Your ref:  
Our ref: 23/01550/F  
Please ask for: Valera Lvov  
Direct dial: 01553 616865  
E-mail: borough.planning@west-norfolk.gov.uk

### **TOWN AND COUNTRY PLANNING ACT 1990**

Details: **PROPOSED SINGLE STOREY REAR EXTENSION, INTERNAL ALTERATIONS AND EXTERNAL FACADE CHANGES at Hill House Farm Bath Road West Dereham King's Lynn Norfolk**

Drawing Number:
23-P21-PL002

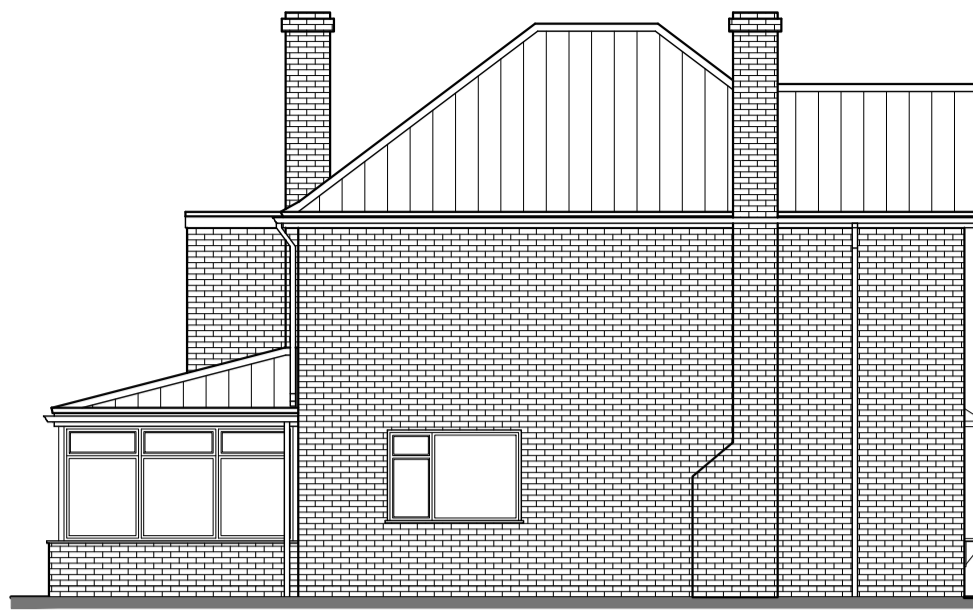
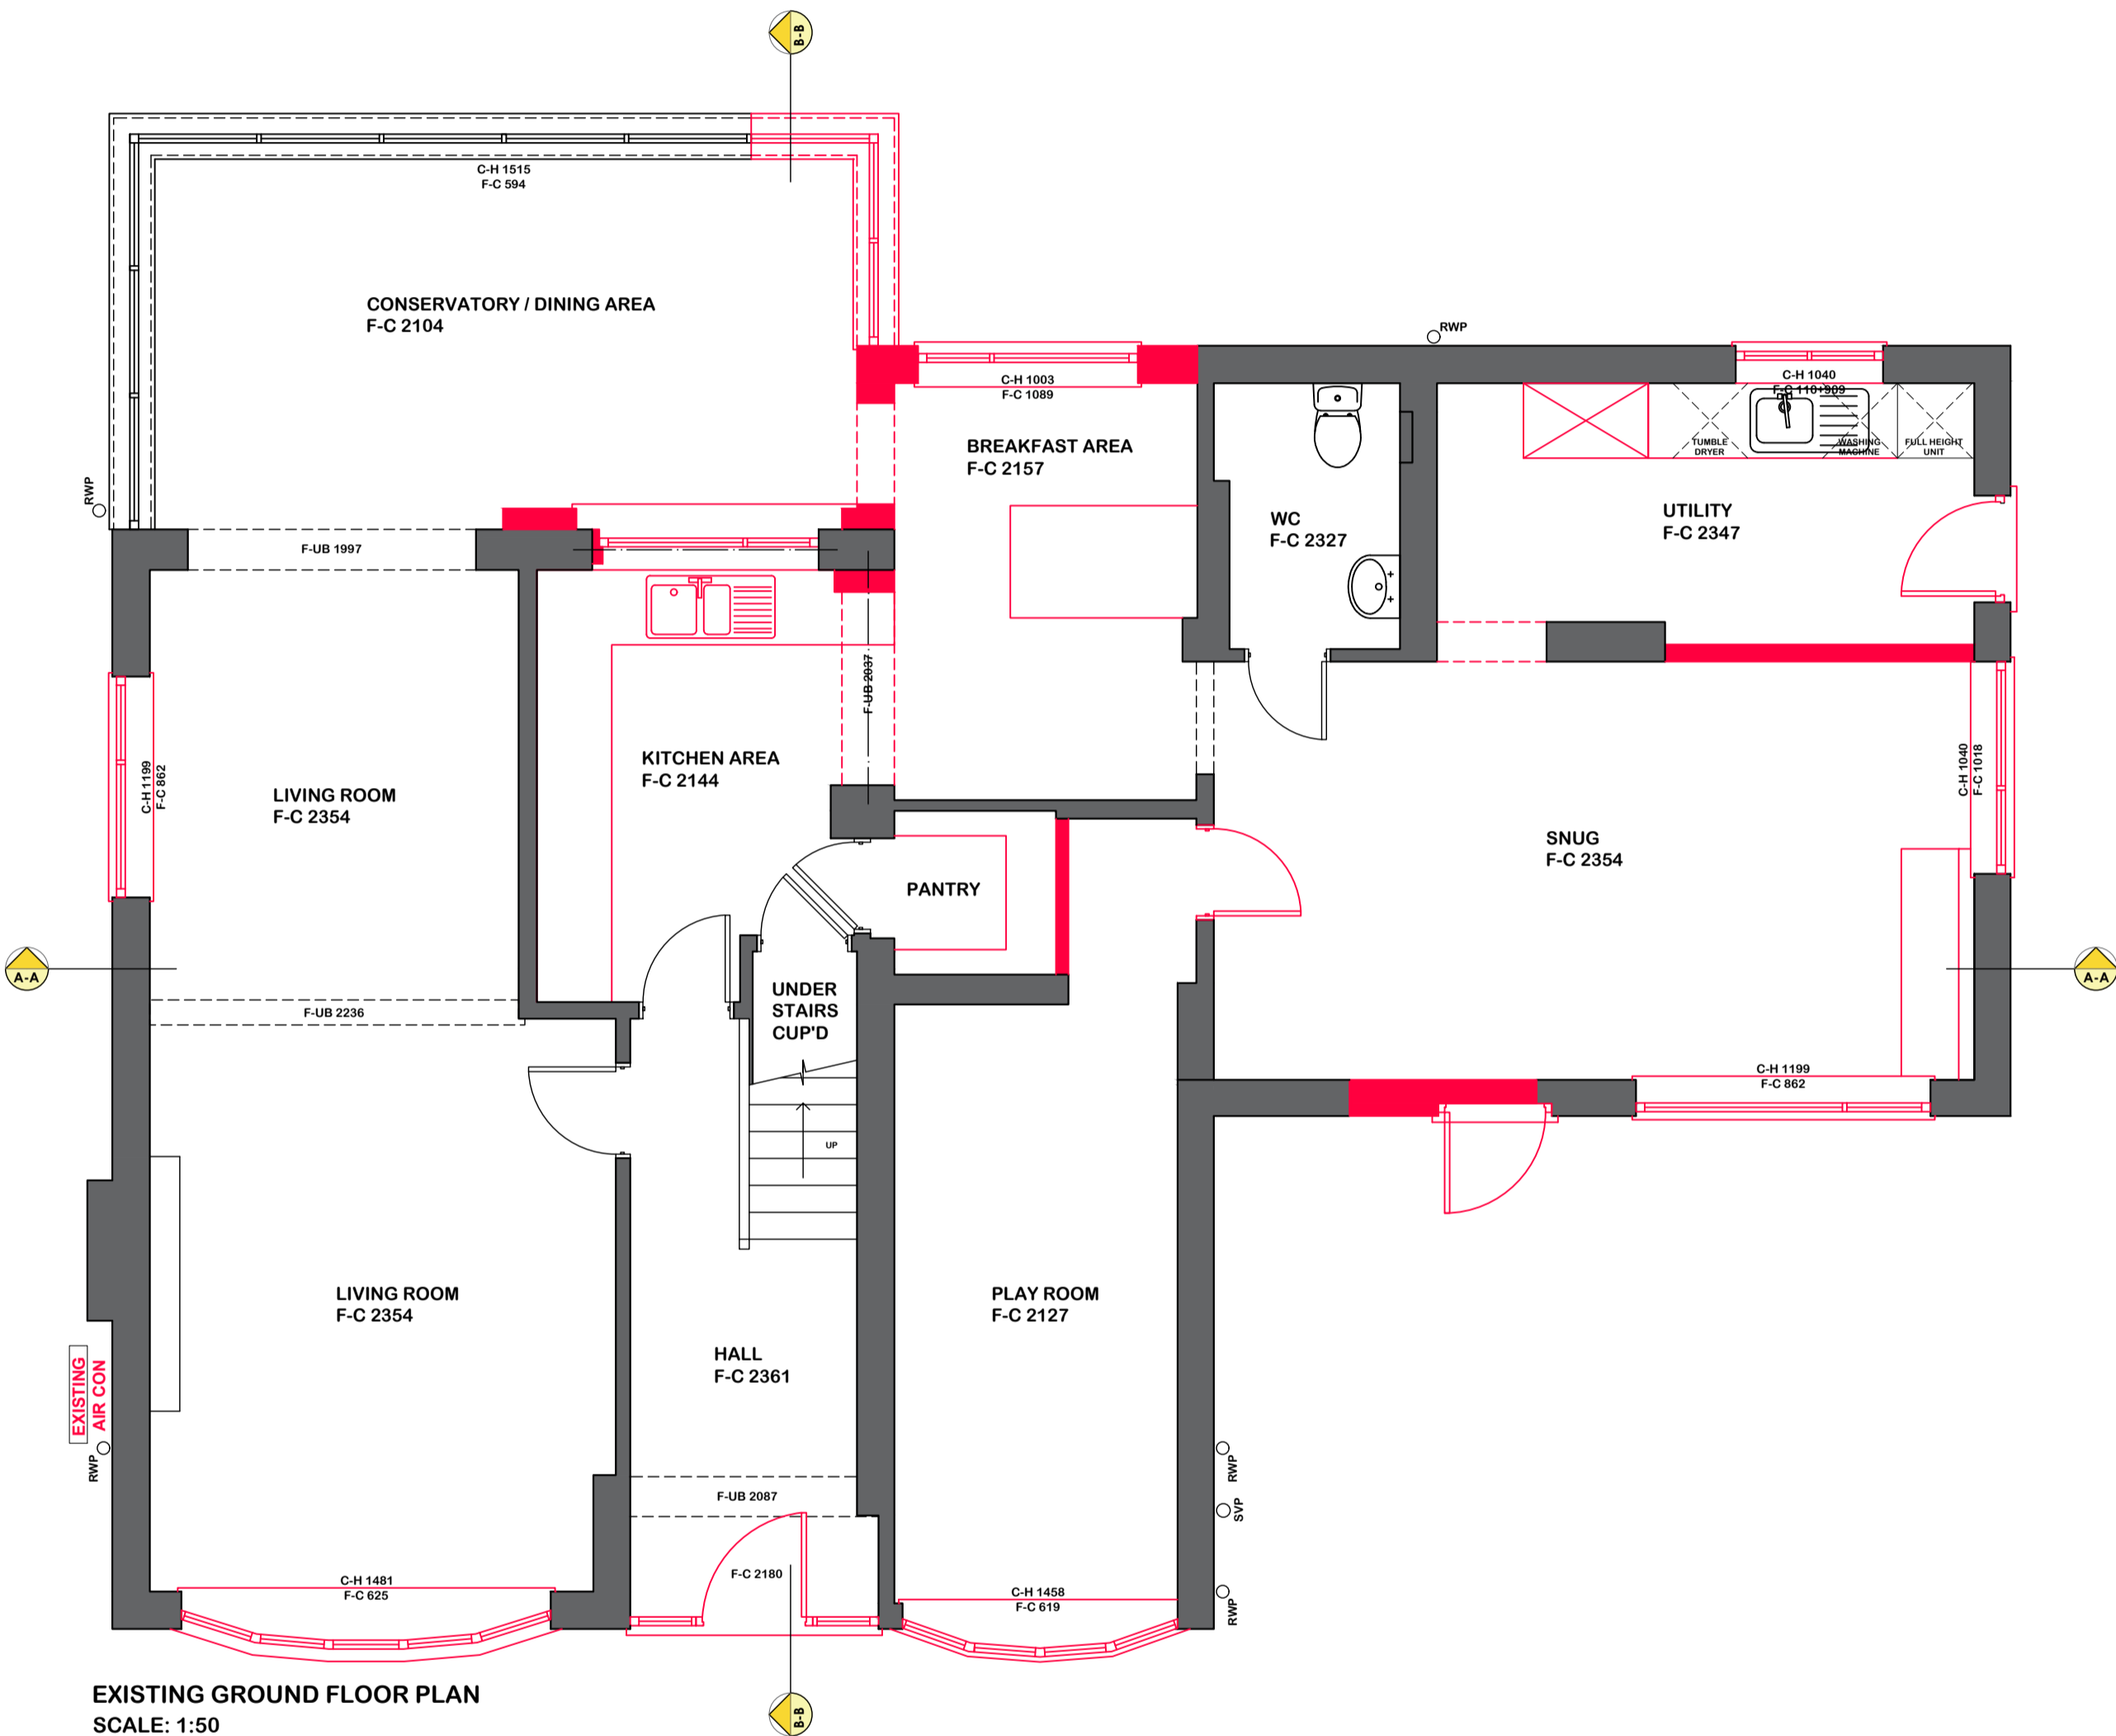
1. The existing ground floor plan is showing 1 door on the front elevation, the existing front elevation is showing 2 doors, please confirm which is correct and provide amended.
